**Re: Major Project MP09_0154
Project Application for a mixed use commercial residential building at
7 Railway Street, Chatswood**

SUBMISSION TO DEPARTMENT OF PLANNING ON MPO9_0154 FOR A PROPOSED MIXED USE RESIDENTIAL COMMERCIAL BUILDING AT 7 RAILWAY STREET CHATSWOOD

SHADOW DIAGRAM - MARCH 20TH / SEPTEMBER - 9am

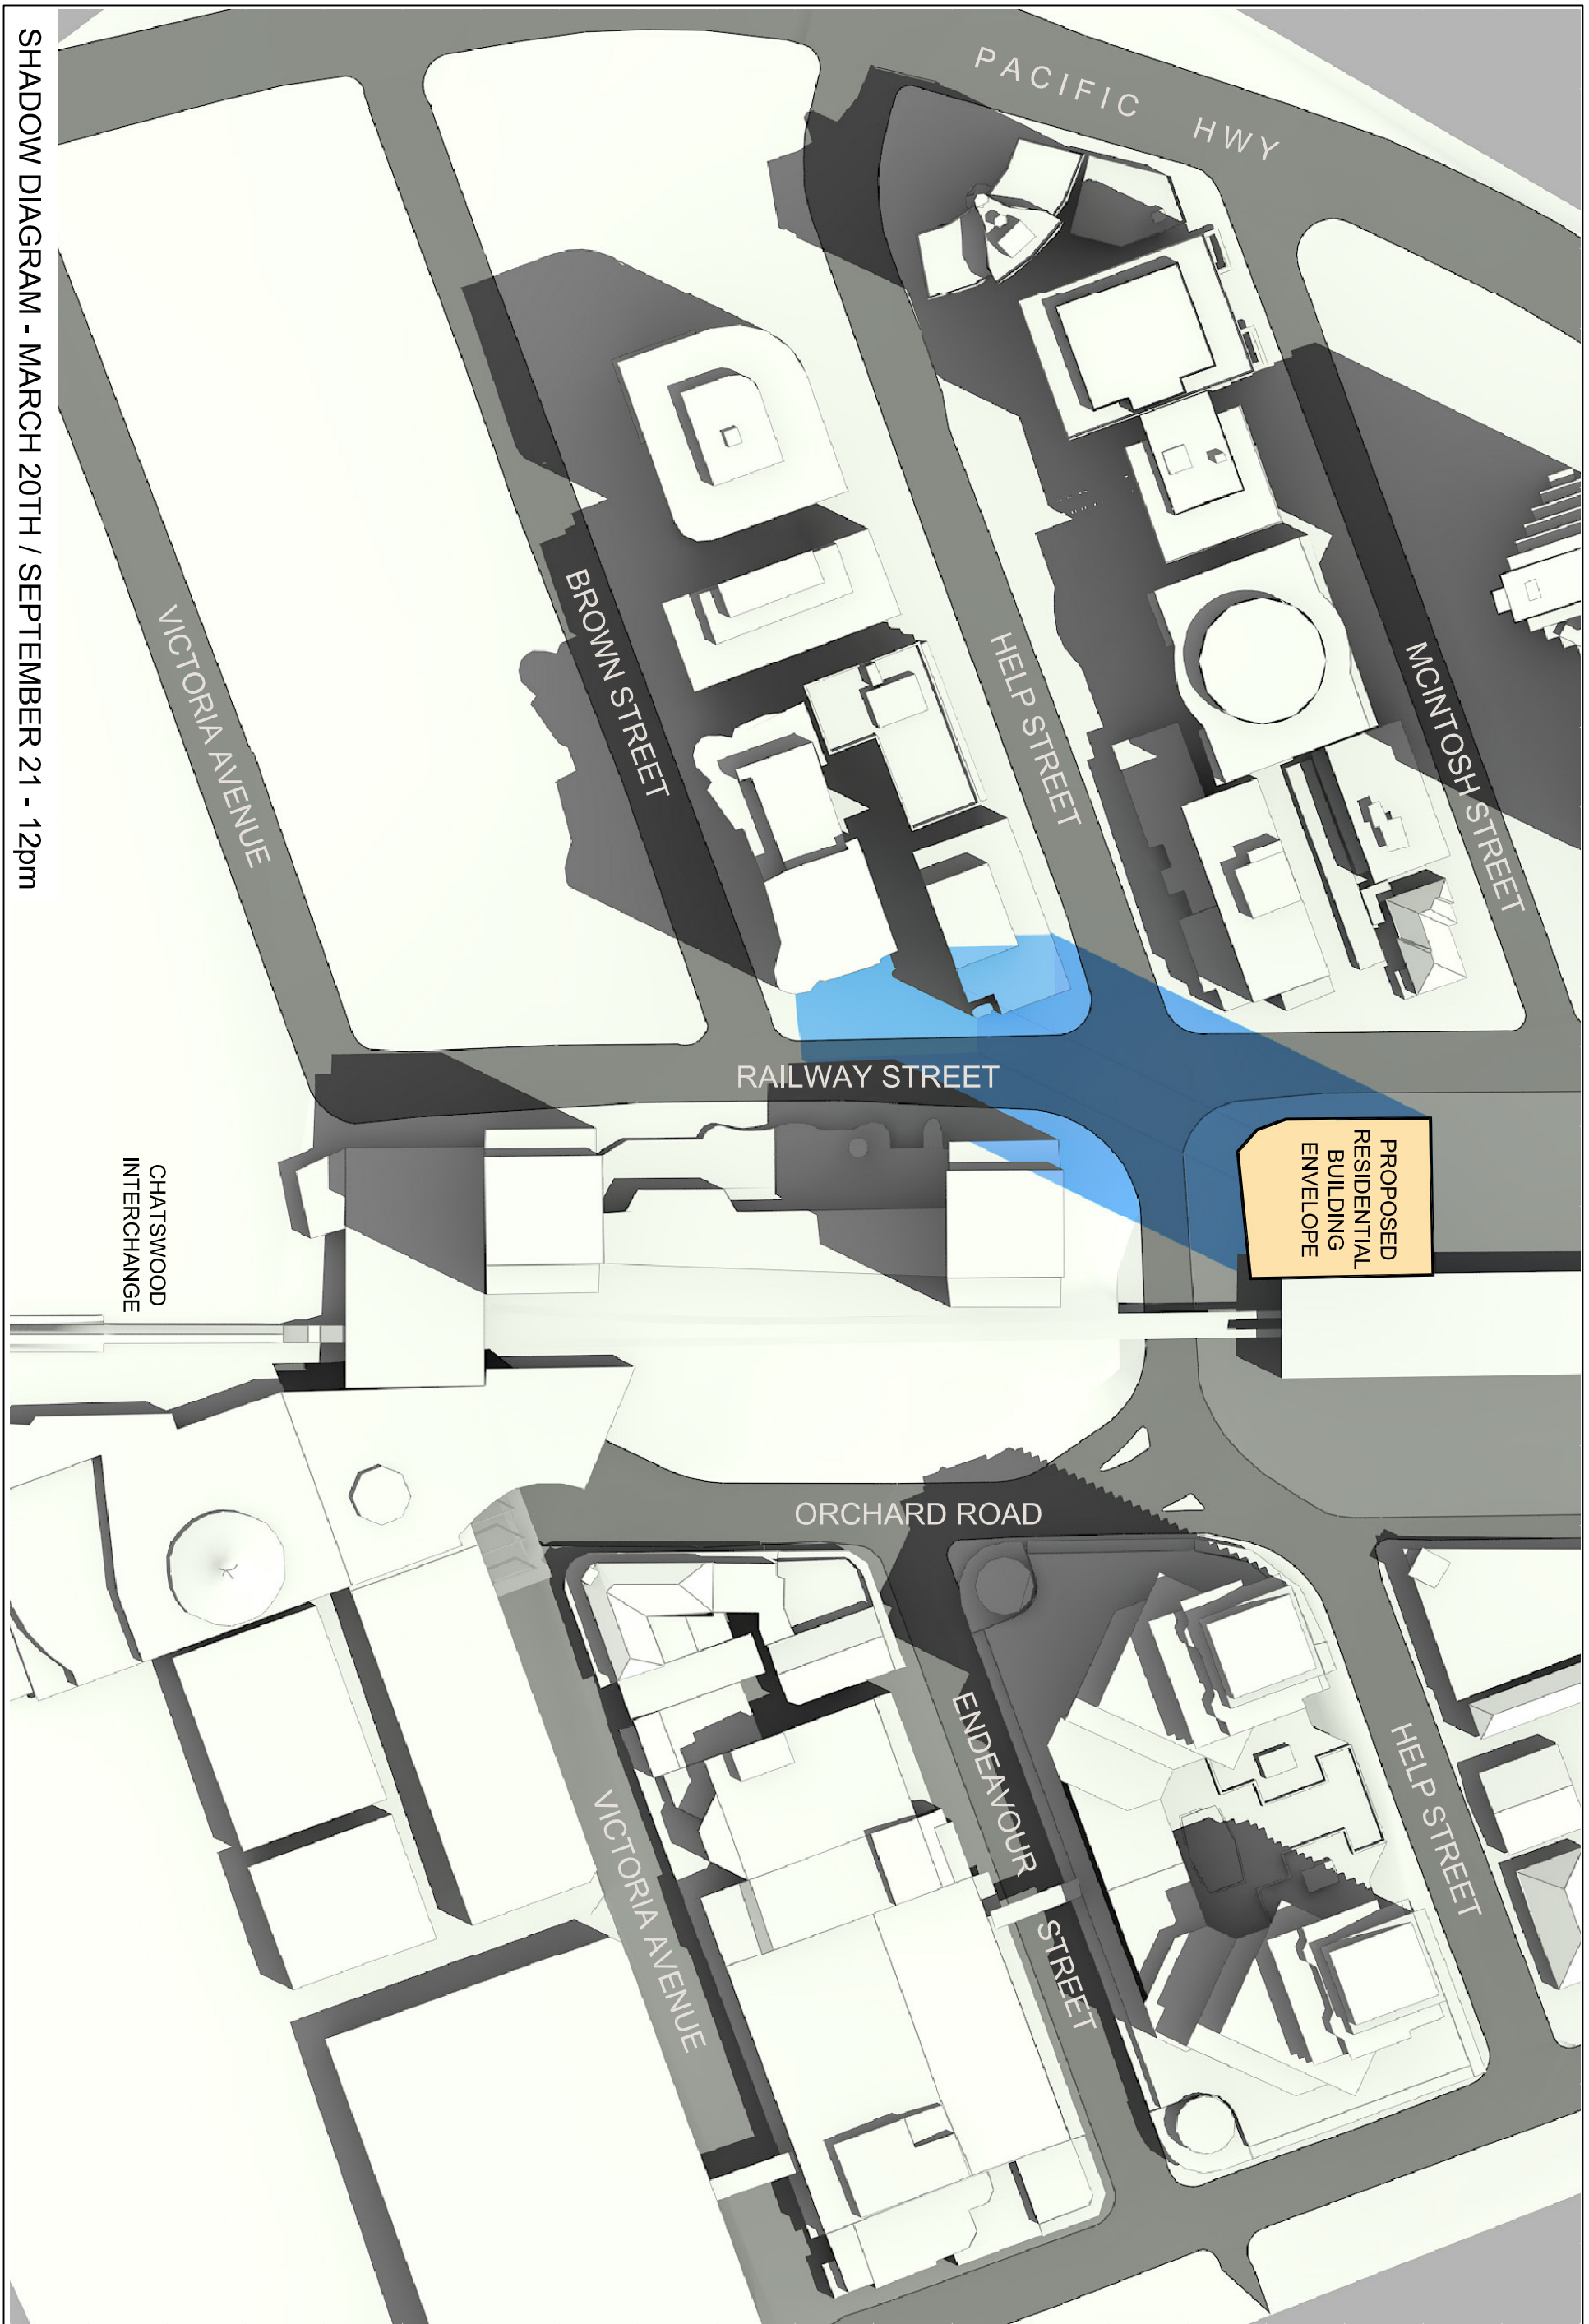
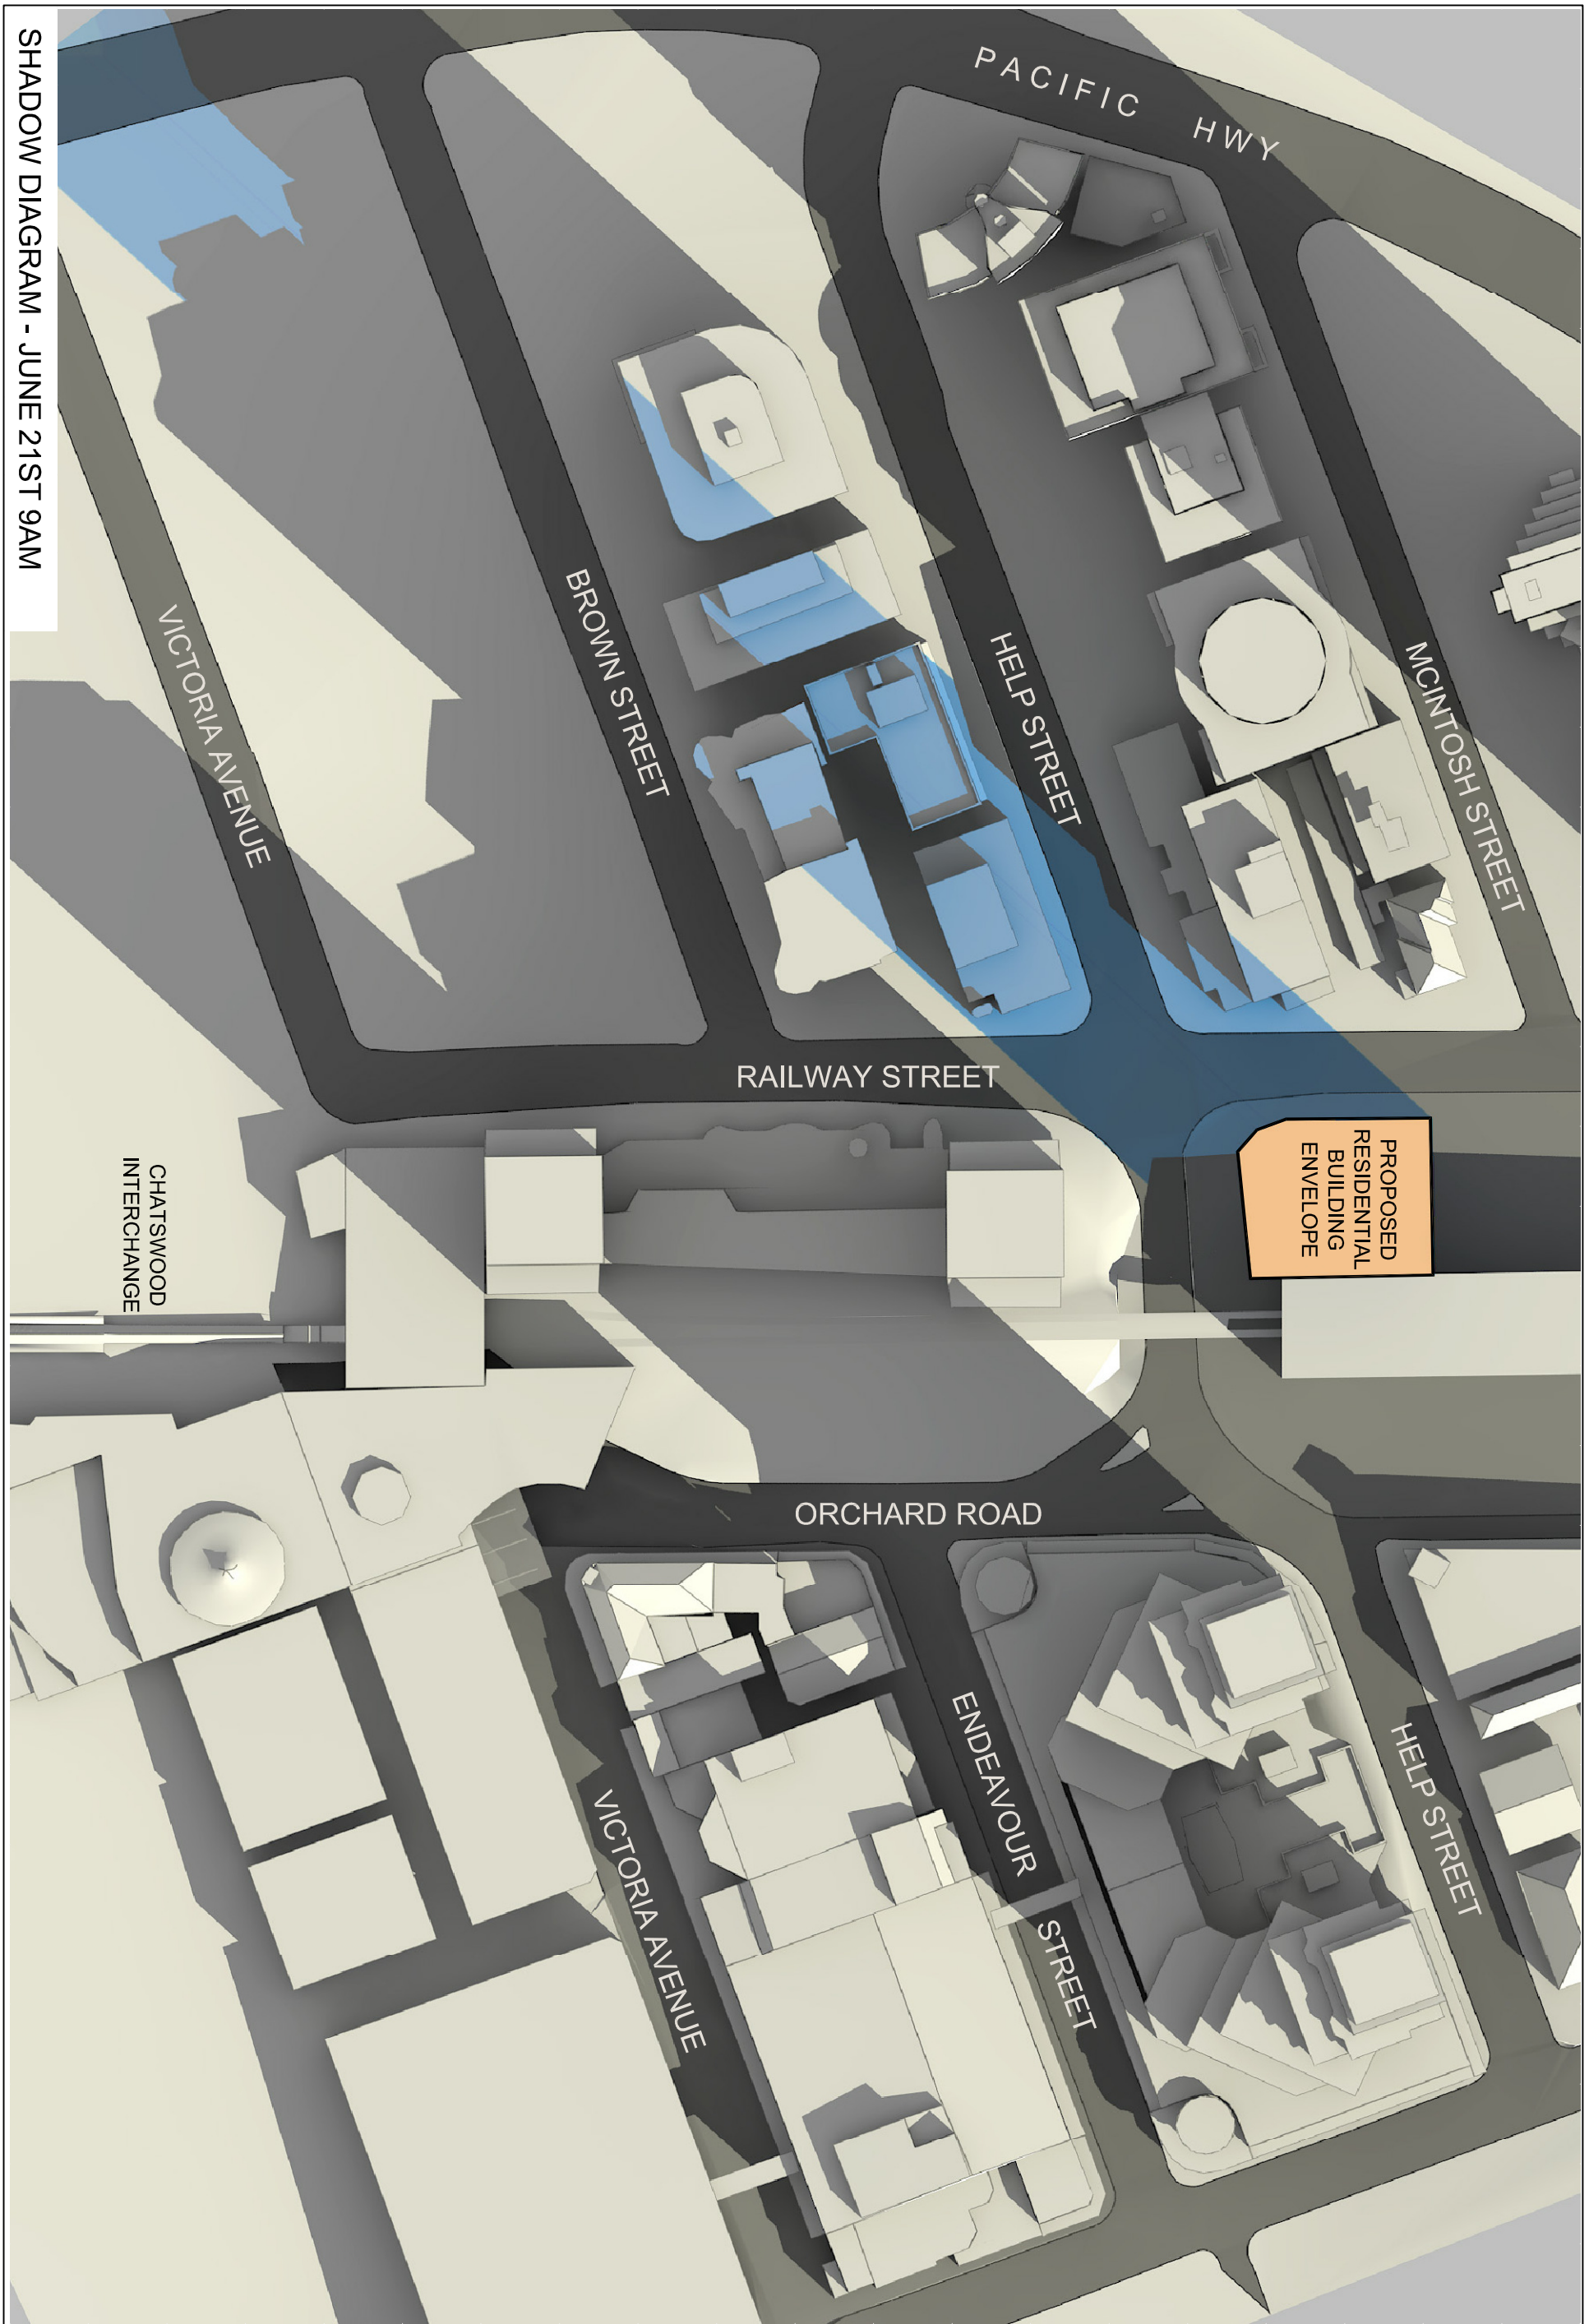
5. The application should be refused as the shadowing impacts on the public domain have not been adequately addressed and Council is concerned that the shadowing from the additional height will adversely impact the public domain of Chatswood.
